KALF AND ASSOCIATES Pty Ltd
Hydrogeological, Numerical Modelling Specialists

30 September 2013

Cobbora Coal Project - New Mine Plan Proposal
3rd KA Groundwater Adequacy Review

Figure 5.6A Drawdown in water table aquifer after 21 years / end of mining

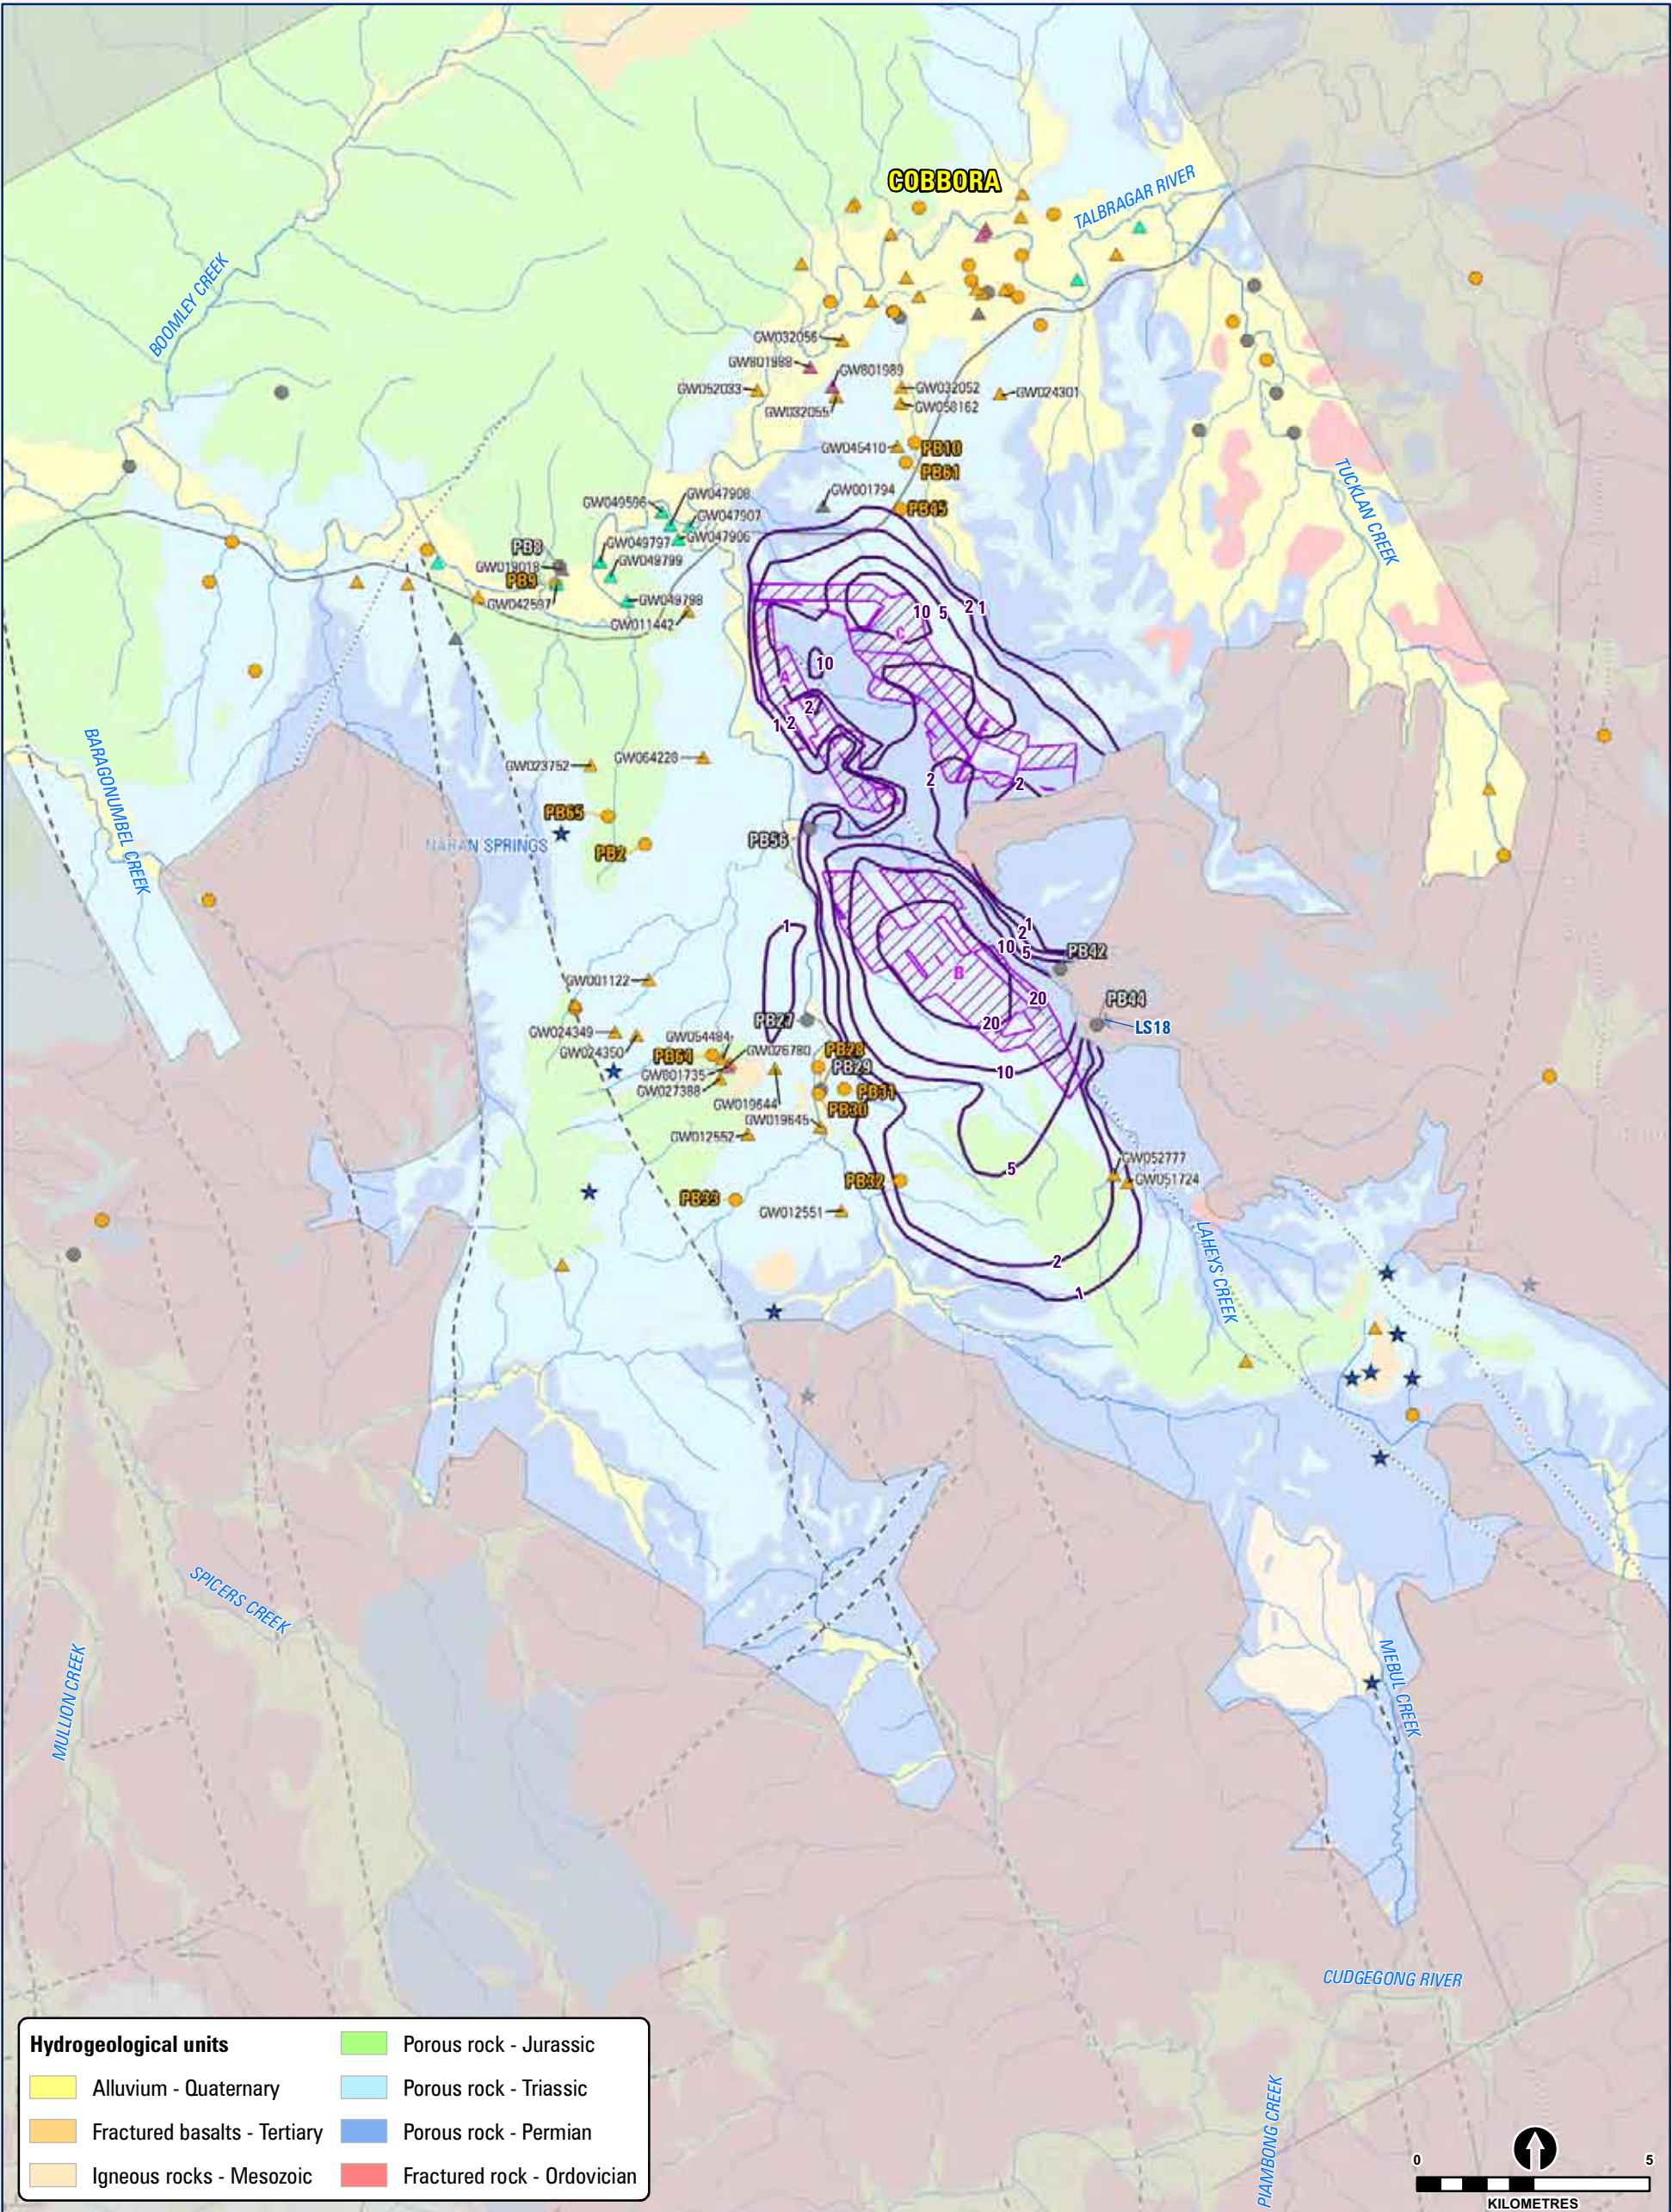
However, the main item of contention in the KA response was related to the cross-sections provided by PB. This section indicated (Fig 5.6D in Appendix H)¹ that drawdown west of the mine site did not propagate beyond the boundary condition modelled for Sandy Creek. This indicated that Sandy Creek would be providing a constant source of leakage surface water into the modelled groundwater system even though it is a ephemeral creek channel. Consequently, such a condition would therefore underestimate the drawdown propagation beneath and beyond the Sandy creek channel and hence very likely create in the long-term much greater drawdown in private and other bores located in this region.

Final Landform Cross-sections

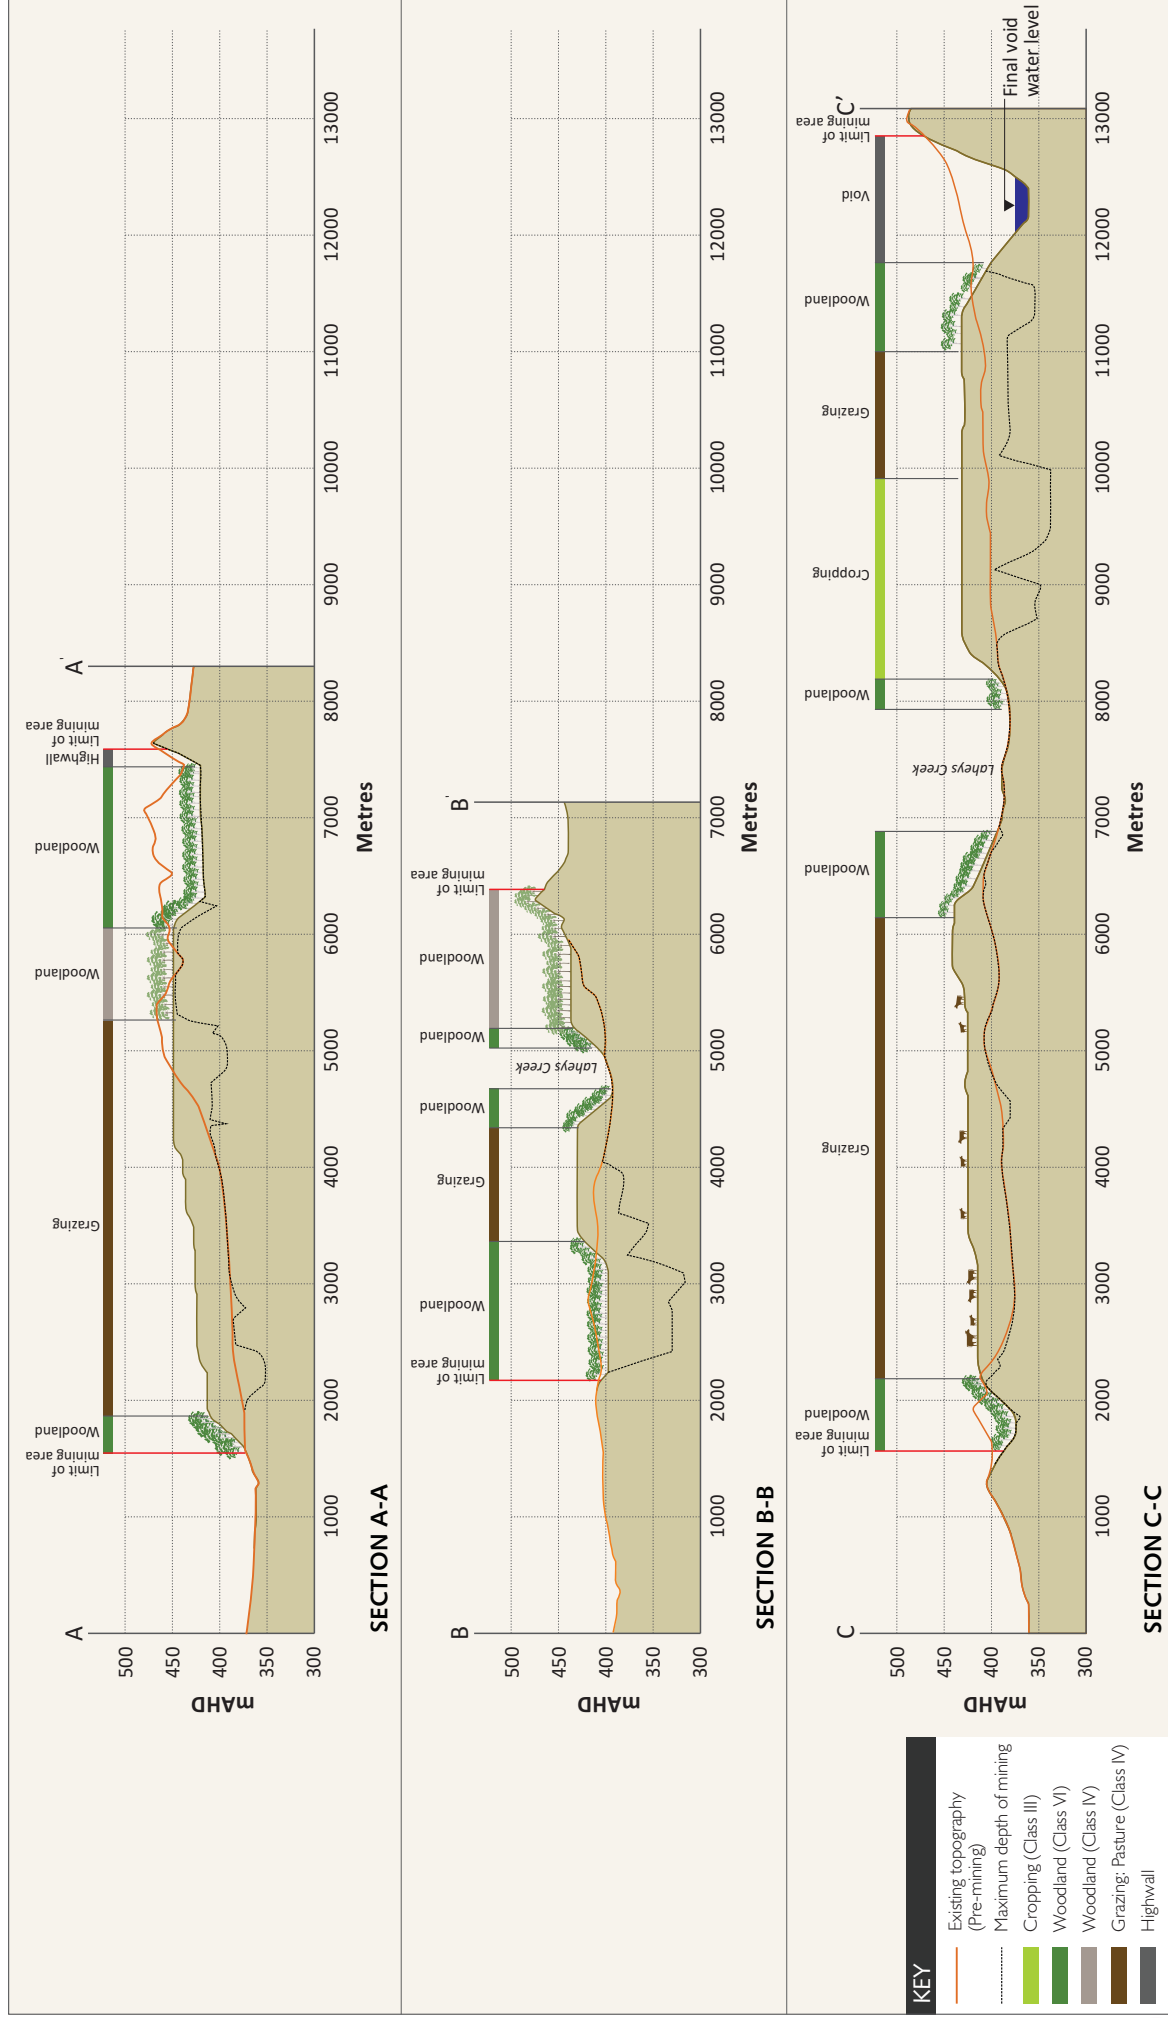
e) a revised cross-sectional diagram is requested of the final land form to illustrate surface and groundwater features and final void geometry. The proponent's consultant has indicated that these features will not change significantly compared to that illustrated previously and that a cross section of mining area B is presented in Figure 3.15 of the PAC responses report (EMM 2013b Main report).

1. With regard to NOW's comments a) to f) above there is agreement with the proponent consultant's response comments with the following additions. With regard to b) it will be necessary to verify this conclusion with an update to the groundwater modelling for the revised mine plan. With regard to e) updated cross-sections could be generated from the updated modelling results proposed as part of the management plan before mining commences. f) would need to be determined as part of the revised modelling proposed by the proponent's consultants.
